**KIRKLEES METROPOLITAN COUNCIL  
INVESTMENT & REGENERATION SERVICE**

Reference No:	<b>2025/44/91050/E</b>
Site Address:	Shawcross 170, Churwell Vale, Shawcross Business Park, Dewsbury, WF12 7RD
Description:	Discharge of details reserved by condition 12 (Lighting Scheme) on previous permission 2023/93486 for reconfiguration of building, re-orientation of car parking and service yard, erection of a noise barrier and external alterations
Recommending Officer:	Nina Sayers

## Officer Report

#### Condition 12 – Lighting Strategy

**EXTERNAL LIGHTING
AND DUCTING LAYOUT
SHEET 2 OF 2**

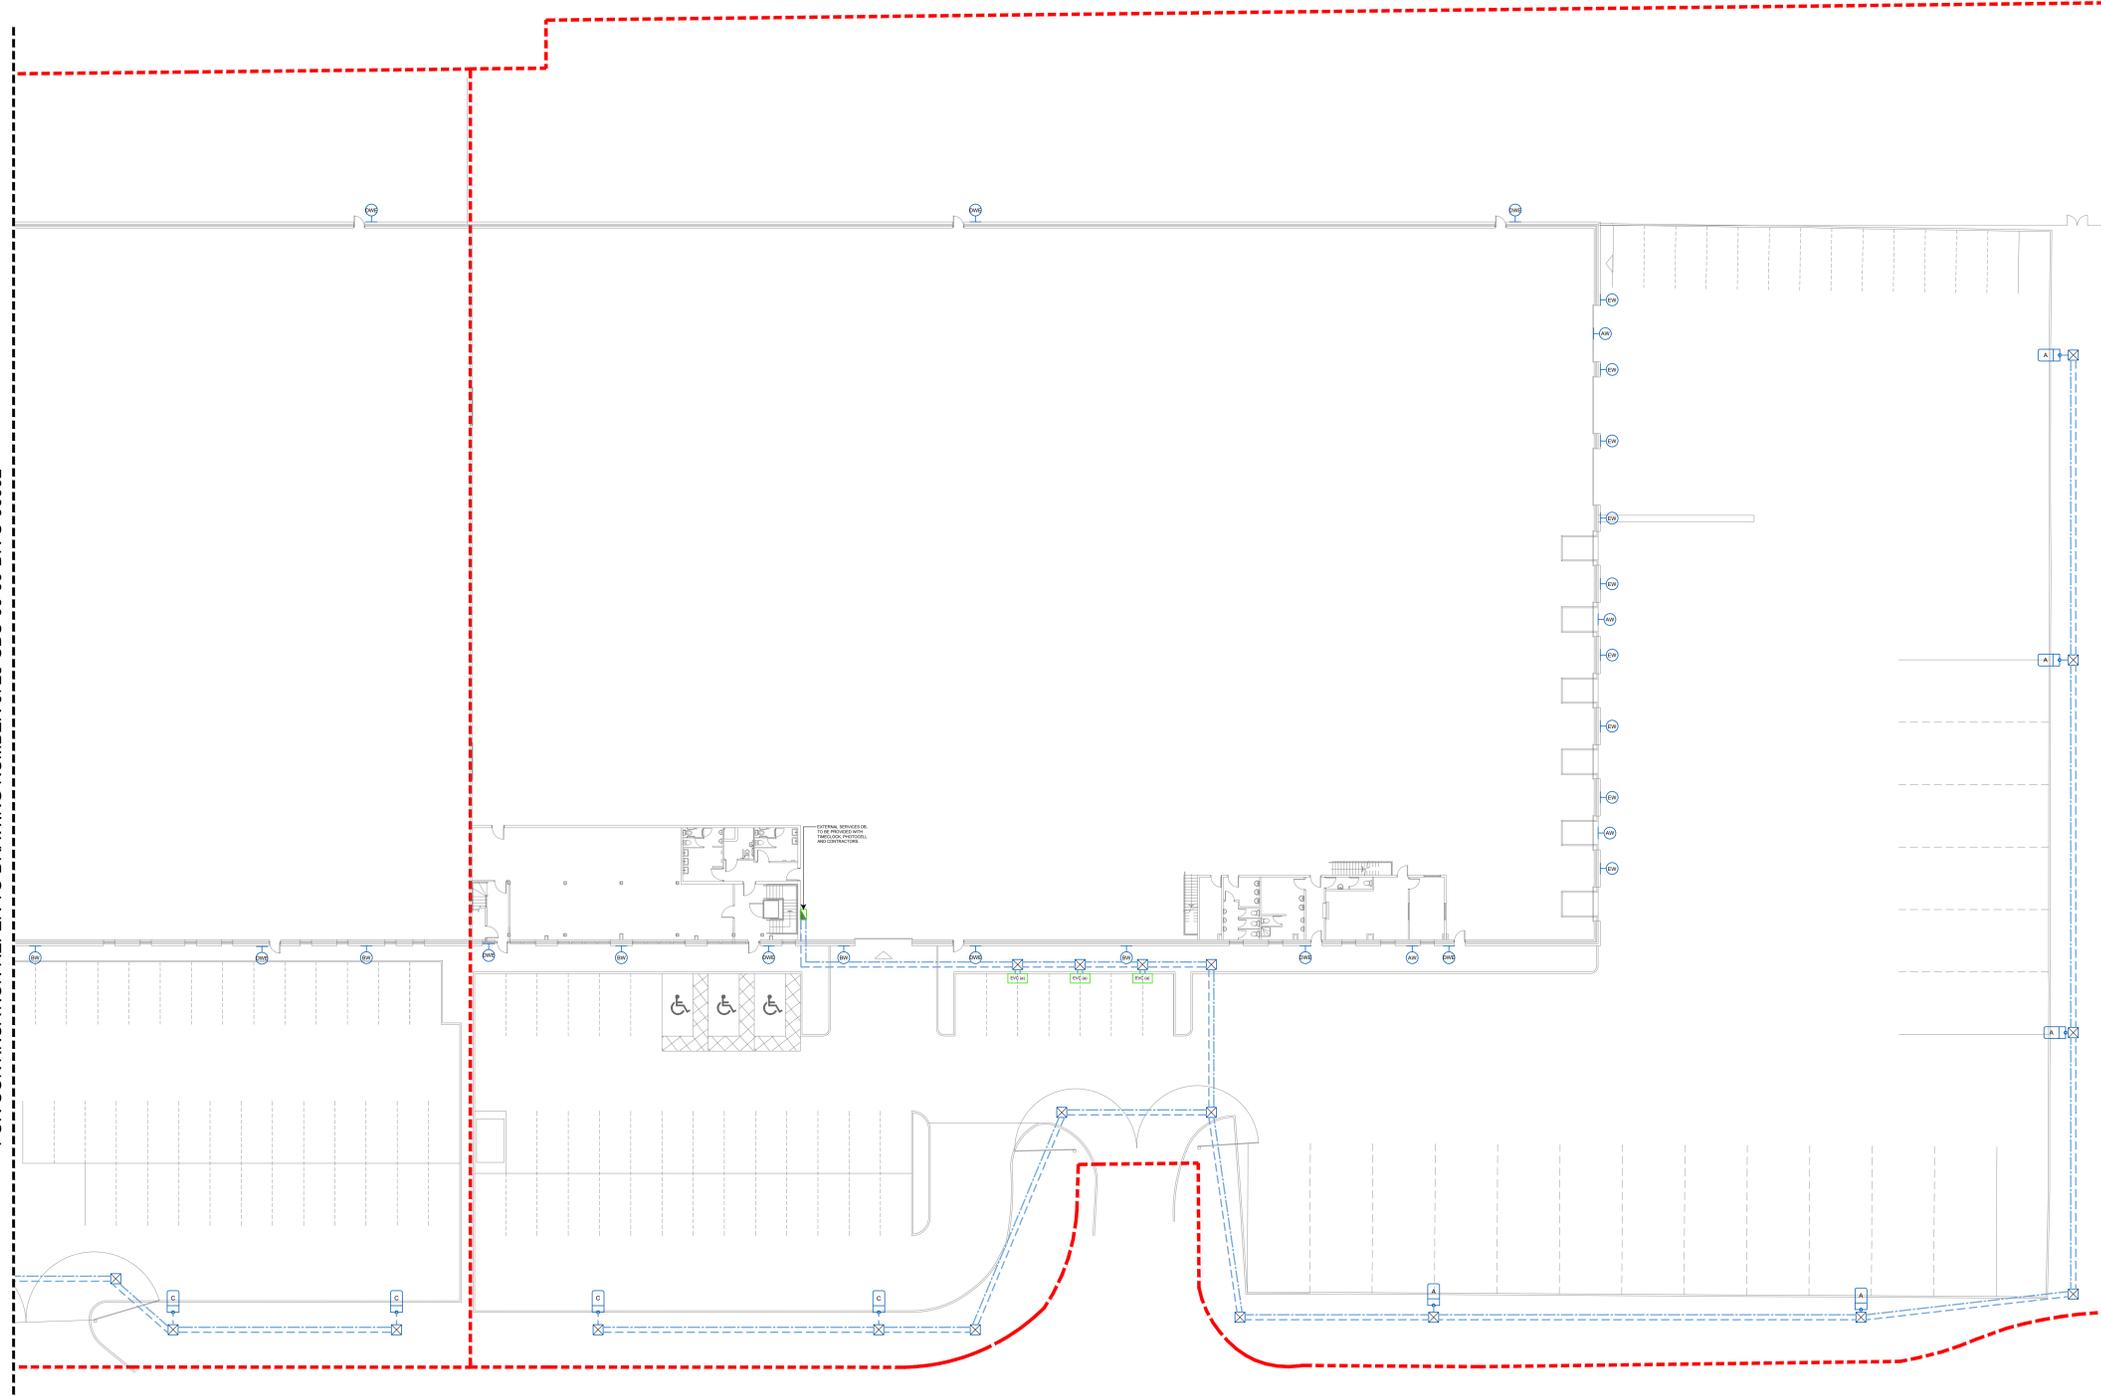
- The proposed design level of maintained average horizontal illuminance for the areas that needs to be illuminated has not been provided. It is noted that the cover letter refers to a plan titled Kingfisher Lighting Design however this has not been submitted with the application. Officers need to review a LUX plan or similar which shows the maintained average horizontal illuminance
- Whilst details state that to minimise or eliminate glare and stray light arising from the use of the lighting a number of the lights will be low glare. Officers need to see on a plan which specific lights are low glare as this is not clear from the information provided.
